**Reference: Rule 8 letter for the M42 Junction 6 Improvements – Woodland Trust  
Examination Questions**

The Woodland Trust would like to take the opportunity to respond to the questions posed by the Planning Inspectorate in relation to the M42 Junction 6 Improvements Development Consent Order application. The Trust's responses are as follows:

Drawing Title  
**FIGURE 8.3 PROPOSED LANDSCAPE PLANTING SHEET 1 OF 3**

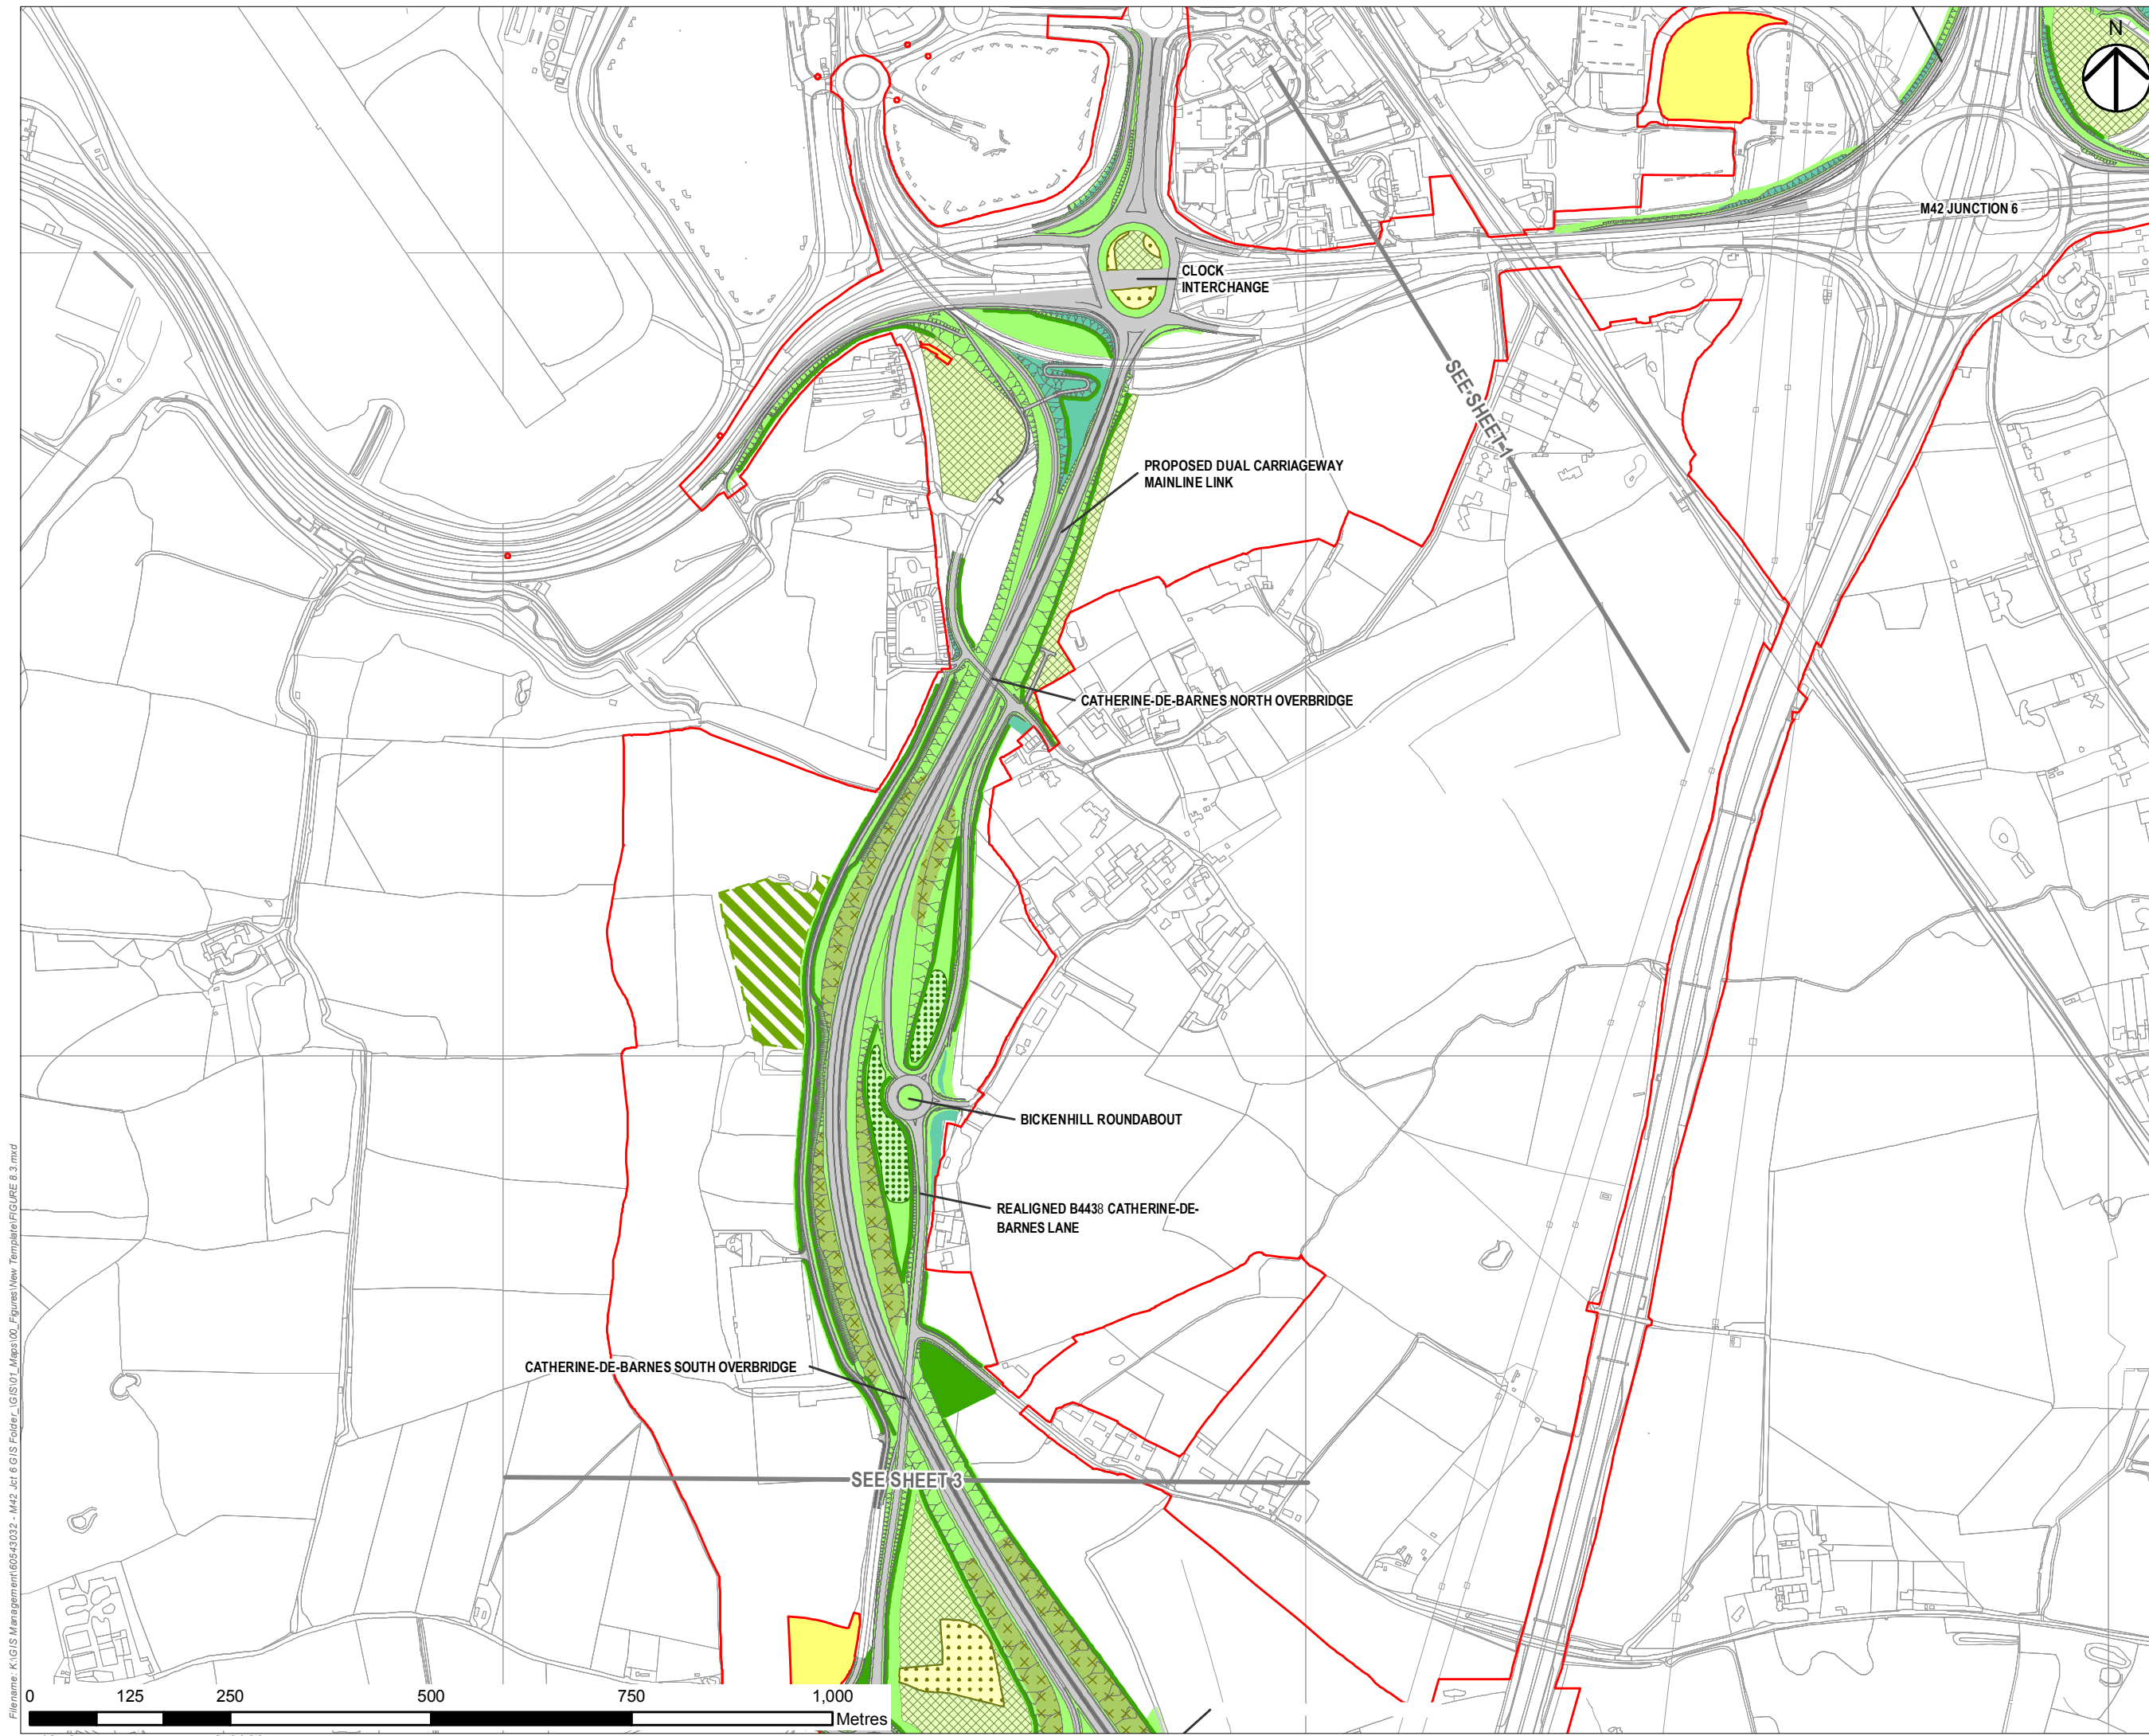
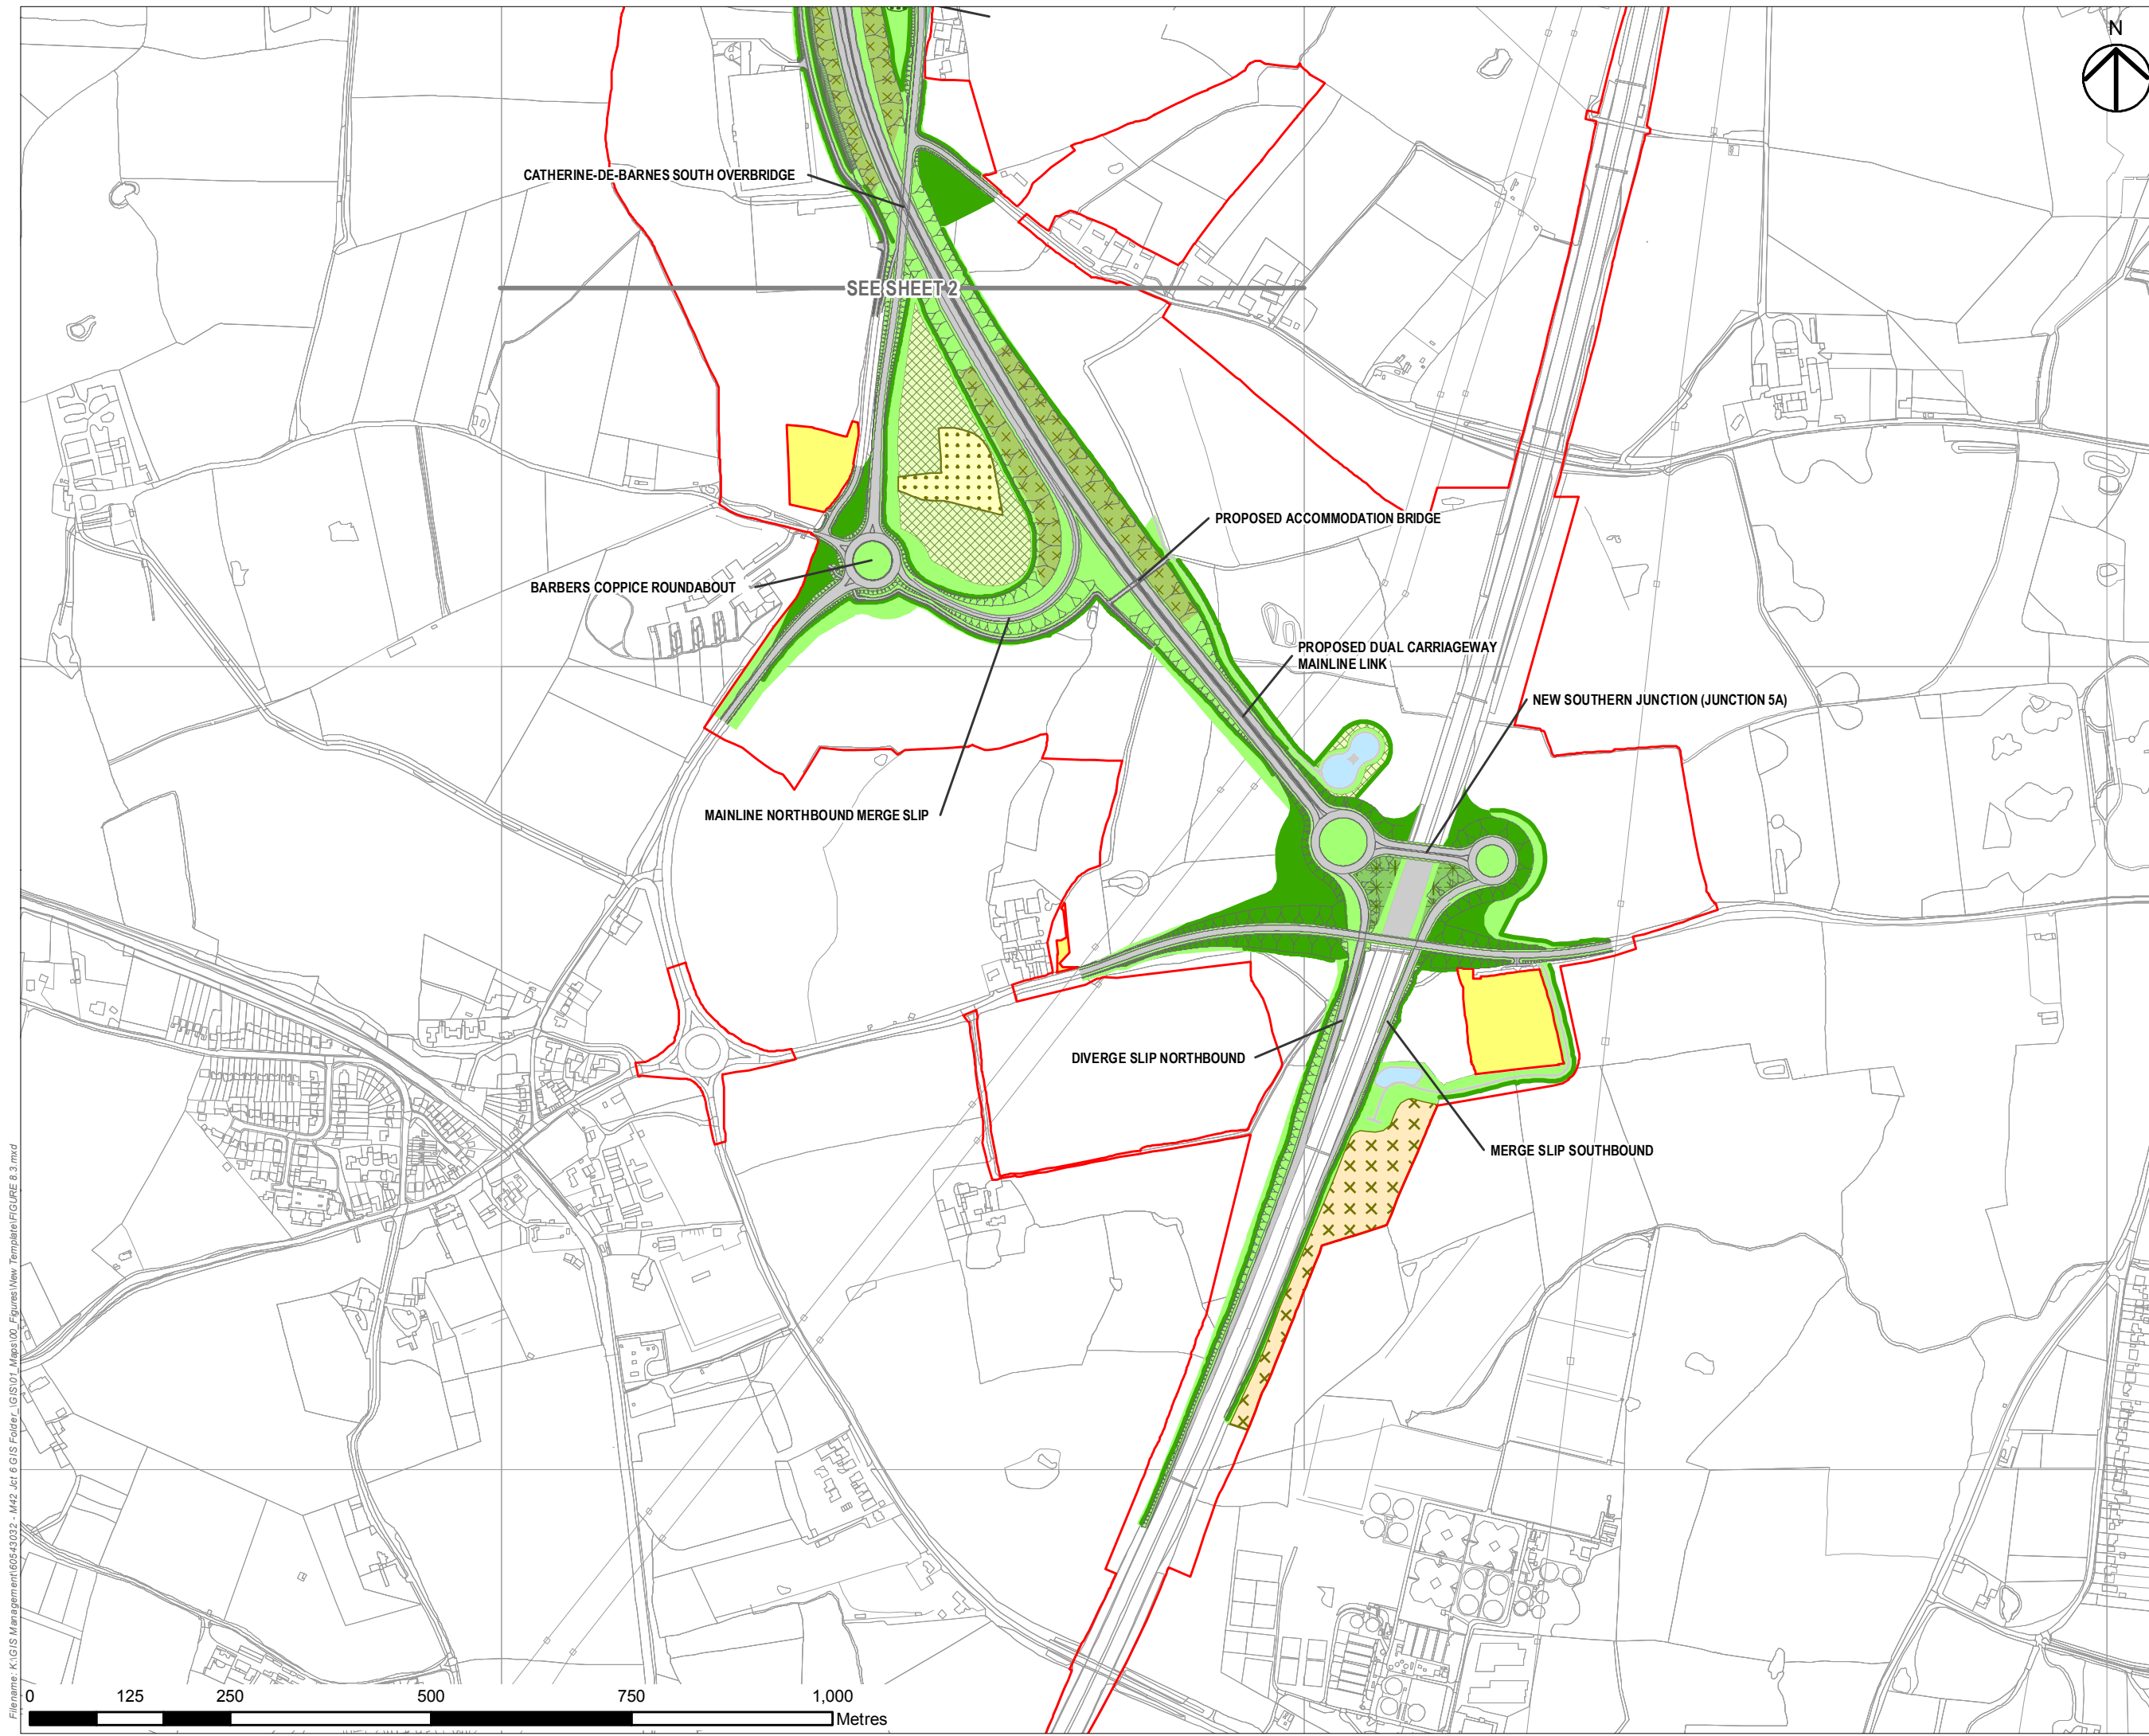
**1.7.25: The Applicant, NE and the Woodland Trust are asked how the success of the new woodland planting and translocation of ancient woodland soils and habitat might be affected by the proposed area being adjacent to the eastern boundary of the M42 motorway and new slip road?**

It is unlikely that the translocated soils will be further impacted by the proposed development, as it is the Trust's opinion that the damage to the ancient woodland has already occurred and many of the characteristics of the soil will have already been lost or harmed. One of the key issues that arise where areas of woodland and new planting are sited next to roads or motorways is the inevitable impact from high levels of nitrous oxide and other pollutants by motorway traffic<sup>1</sup>. Such vehicle emissions can impact on vegetation both directly through deposition into the surrounding habitat, or indirectly by atmospheric chemical reactions<sup>2</sup>. Where new areas of planting are established, increasing nitrogen can alter the outcome of competitive interactions, changing the character of woodland vegetation<sup>3</sup> and affecting species composition.

**1.7.30: There appears to be little scope to provide effective buffer strips to Asbury's Copse alongside the southern slip roads so as to avoid root damage and to help protect the remaining ancient woodland from damaging edge effects, including chemical run off, air pollution, noise pollution, light pollution and litter. The ExA would welcome comments from the Applicant, NE and the Woodland Trust about this.**

Whilst the Woodland Trust acknowledges that the existing M42 will have resulted in detrimental impact to the ancient woodland, the junction improvements will result in further impacts and direct loss. With the loss of the current edges of the ancient woodland, the core of the woodland – which is typically the most sensitive – and other previously less exposed areas will now be further exposed to the external adverse impacts, as listed above. As it is apparent that the remaining areas of ancient woodland could not be buffered, the Trust remains opposed to this scheme. If ancient woodland is to be lost, then it may be the case that the applicant considers undertaking specialised planting design and careful species selection at the new woodland edge so that impacts to the core of the woodland are lessened.
